DOC19/674602-19

**Environmental Impact Statement Exhibition
Maxwell Underground Coal Mine Project (SSD 9526)**

ATTACHMENT A – EPA additional information requirements

Figure 8-1: Locations considered as part of the contemporaneous cumulative impact assessment

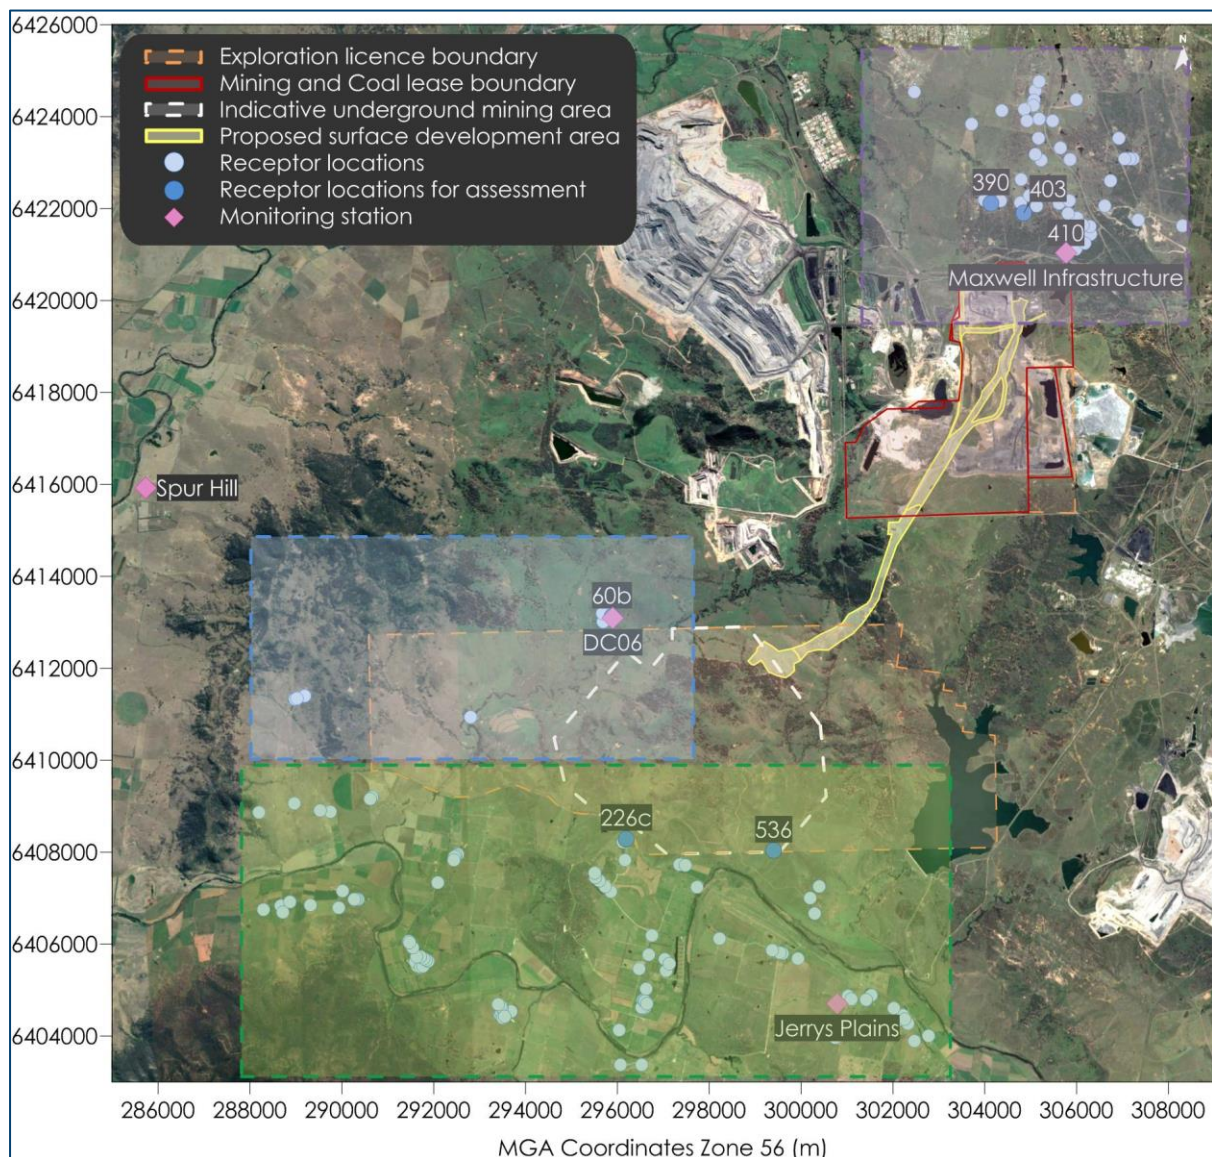
- Segregated results for the cumulative impact assessment of the short- and long-term averaging periods, including, as a minimum:
 - Project (only) increment,
 - Other modelled sources,
 - Monitored background and/or 'residual dust level', and
 - Cumulative (total) impact.

The AQIA predicts no additional air quality exceedances due to the proposal but does not clearly present the information used at Sections 7.4.2 and 7.5 to prepare the cumulative impact assessment for expected concentrations for short (24 hour) and long-term (annual) averaging periods.

The AQIA appears to model Total Solid Particle emissions from neighbouring mines and subtracts the results from annual average monitoring results to calculate 'residual dust levels.' This shows background dust levels from sources in the wider area. However, it is not clear how these contributions were incorporated to assess expected cumulative impacts.

Whilst results presented in section 8 and Appendix D include "total impact", it is unclear what concentrations have been included in this "total impact". For instance, results presented in Appendix F include a "Total Cumulative Concentration", which appears to be based on unadjusted measured background levels and predicted increments (project only contribution), though this is not entirely clear in the AQIA;

- Tabulated incremental and cumulative impact assessment results for the most impacted receptors for all particle size fractions and averaging periods. Whilst the AQIA presents

results for locations which represent the closest and most likely impacted receptors, it does not include the cumulative 24-hour results for the receptor at which the highest increments are expected (Receptor 389); and
